29 November 2021

**DISCHARGE OF CONDITION APPLICATION REF. 2021/1006
CONDITIONS 35, 36, 44 OF 2019/1573 – LANDSCAPE DETAILS
SUBMISSION OF REVISED PLANS**

Drawing title	LANDSCAPE PLAN (PLOTS 1,2 & 3)		
Job-Dwg No	12006-2-VL_L01	Rev	D

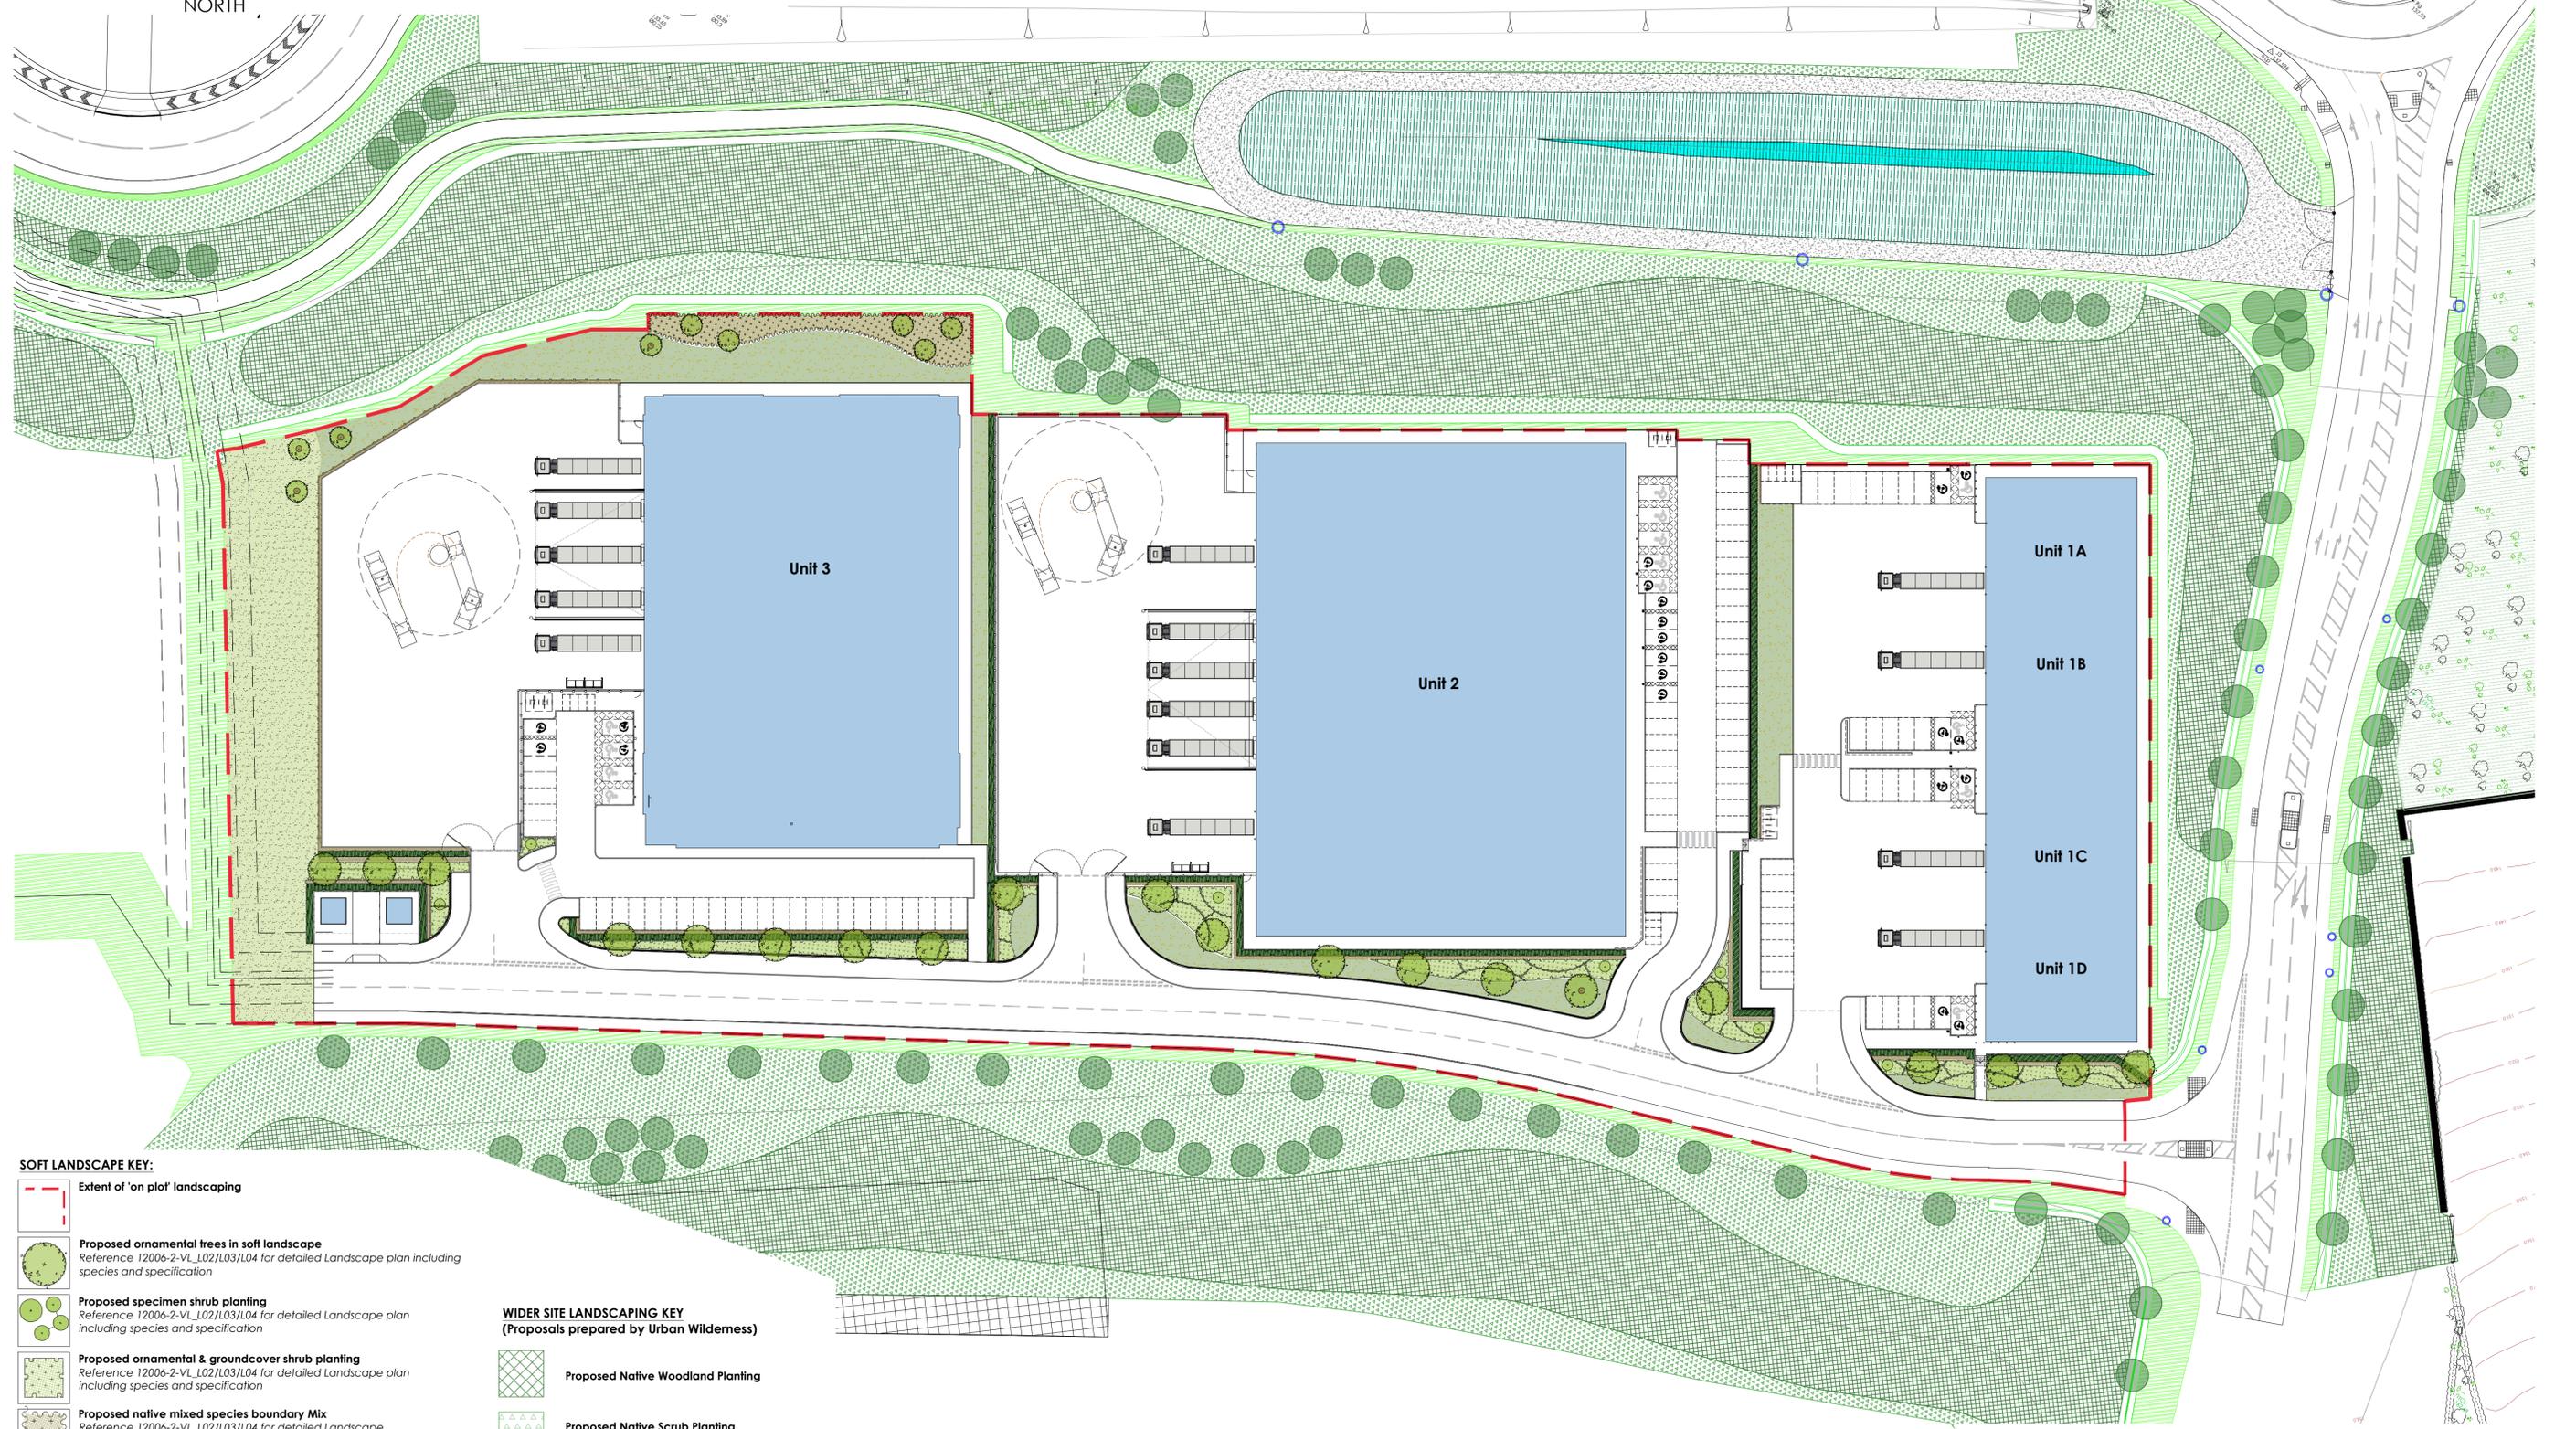
In response to the comments of your Design Officer (as well as your own), we have reviewed and revised the on-plot landscaping scheme. The primary change is the inclusion of a greater number of trees to the road frontage south of the units, which are set within an area of groundcover shrub planting.
